**Case Officer:** Sarah Greenall

**Proposal:** Discharge of Conditions 3 (windows and doors joinery), 4 (slate sample) & 6 (landscaping scheme) of 21/03592/F

DATE: 10 August 2022

Title
PROPOSED SITE LANDSCAPING PLAN

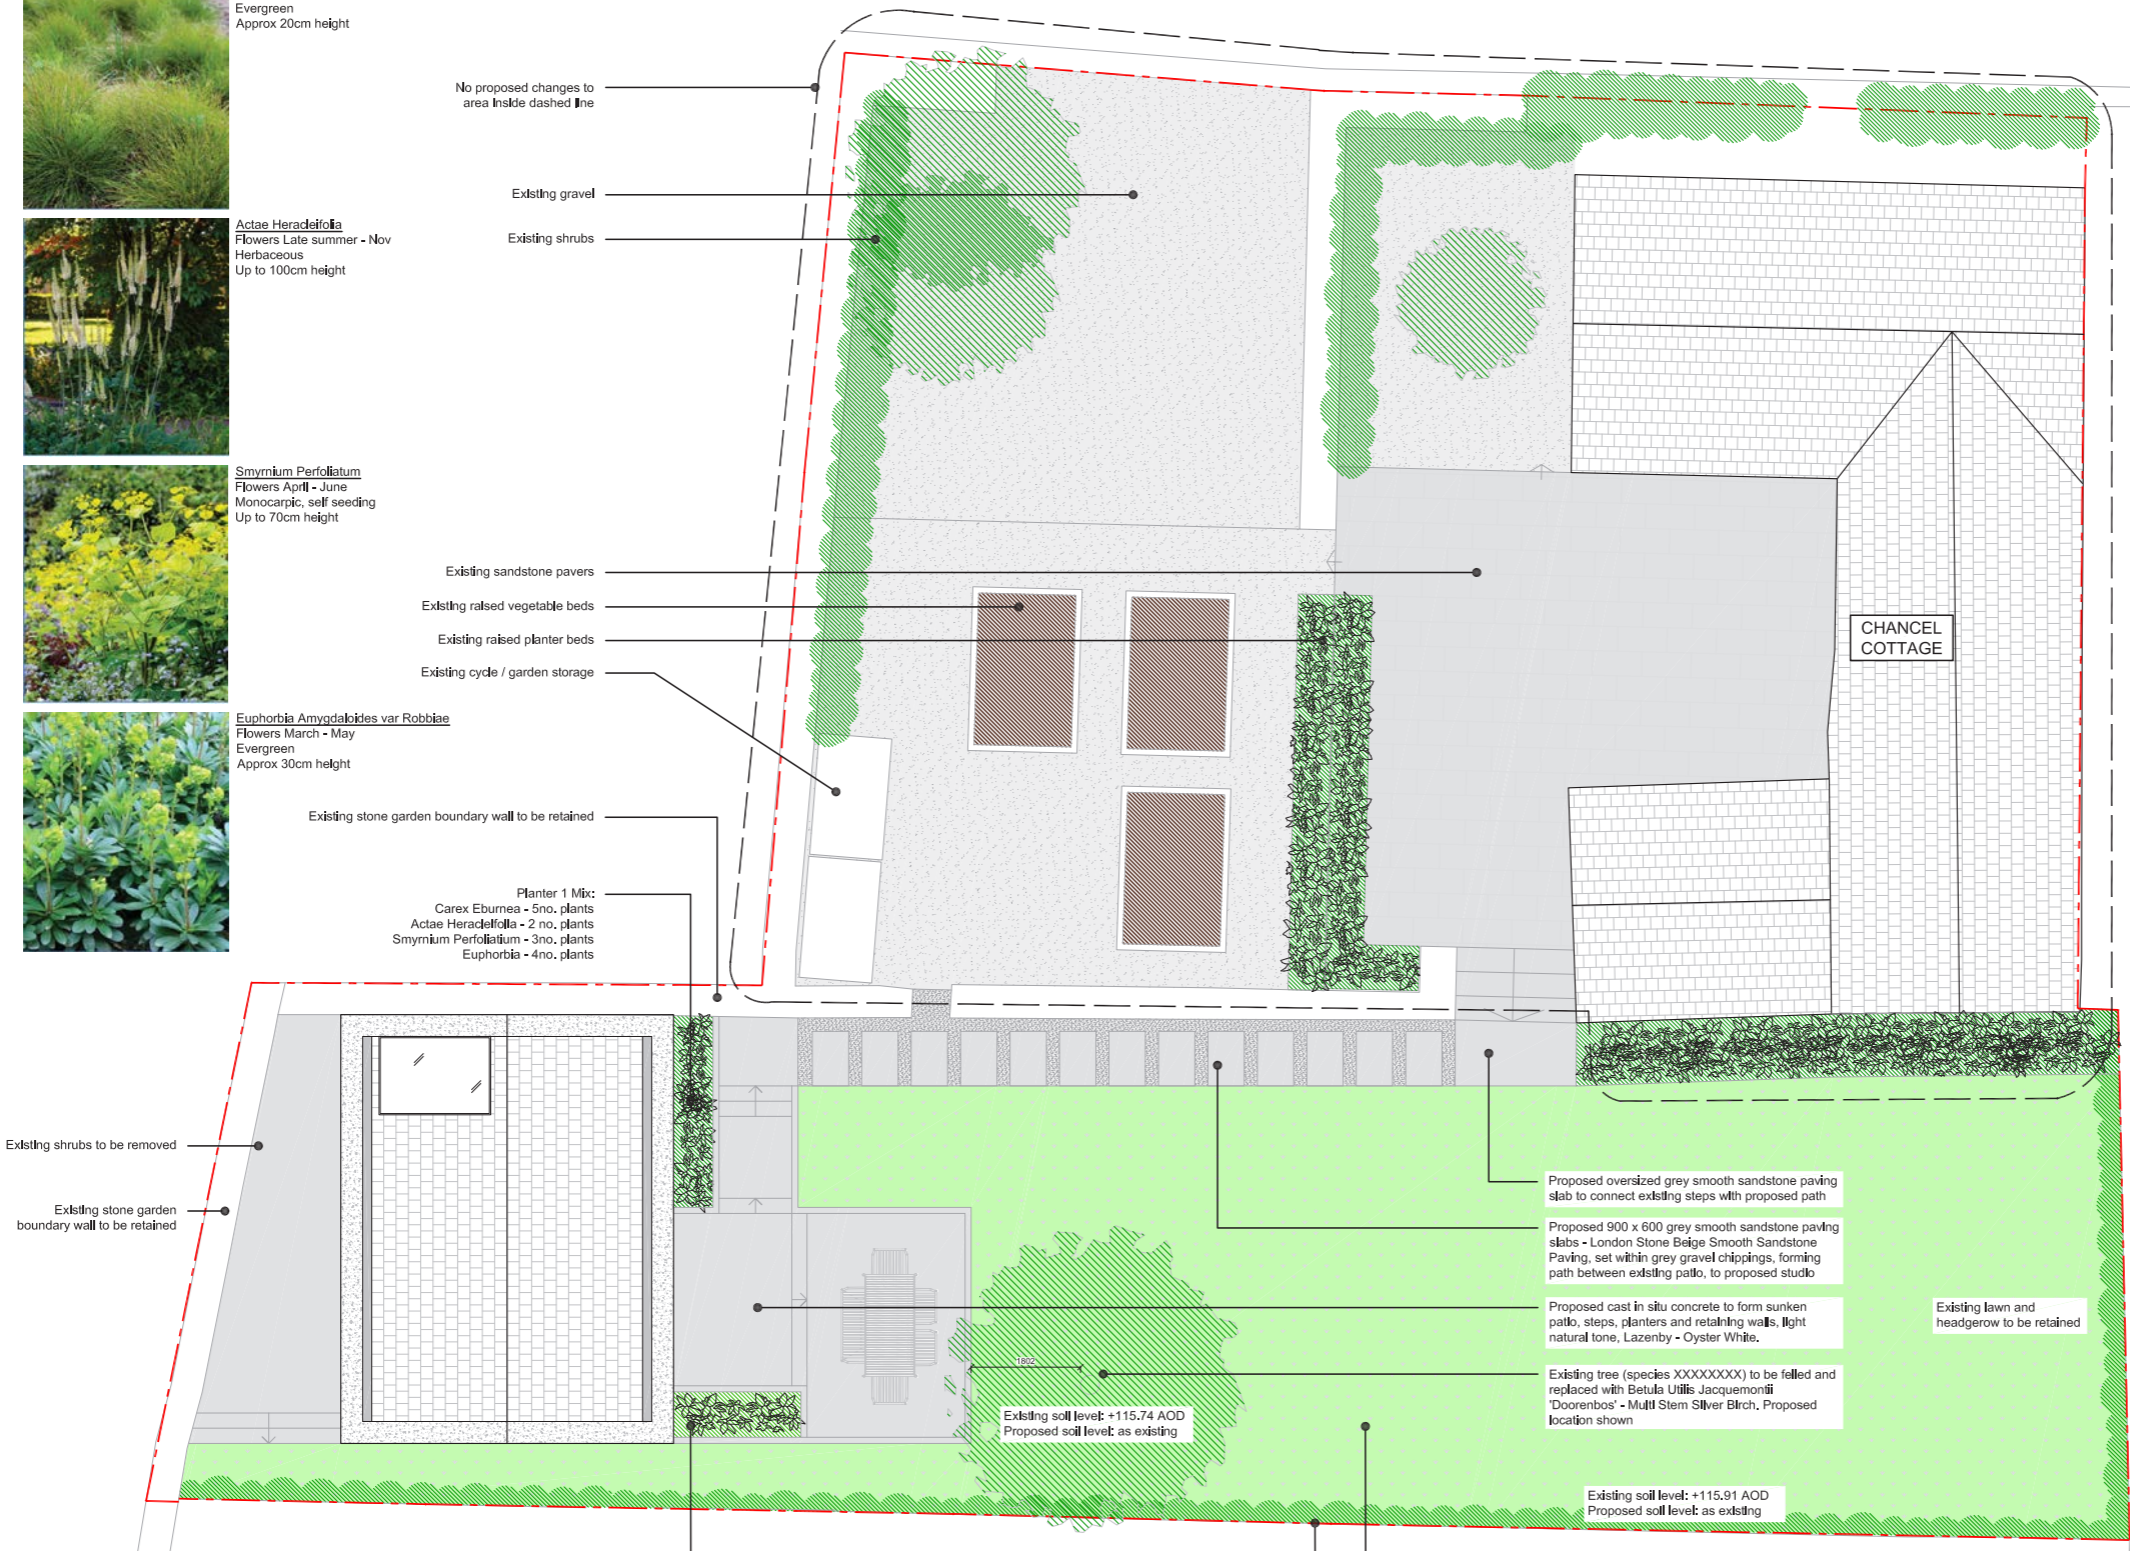
6.3. Lastly, a number of landscape plans have been included in the Planning Condition Schedule document. Areas of hardstanding are proposed in small sections around the proposed outbuilding, and to the north of the new proposed garden area connecting it to the existing areas of hardstanding which would be finished with grey smooth sandstone paving, set within grey gravel chippings. The boundary hedge to the south and remaining grass areas would be retained and a separation between the site and the remaining allotments would be kept in place. The Conservation Officer considers the details to be acceptable from a heritage perspective, and therefore it is not considered that the landscaping would result in harm to the setting of the listed building, thus can be considered acceptable.

Landscaping in accordance with page 7, 8, 9, 10, 11 and 12 of the Planning Conditions document produced by Studio Hallett Ike dated March 2022
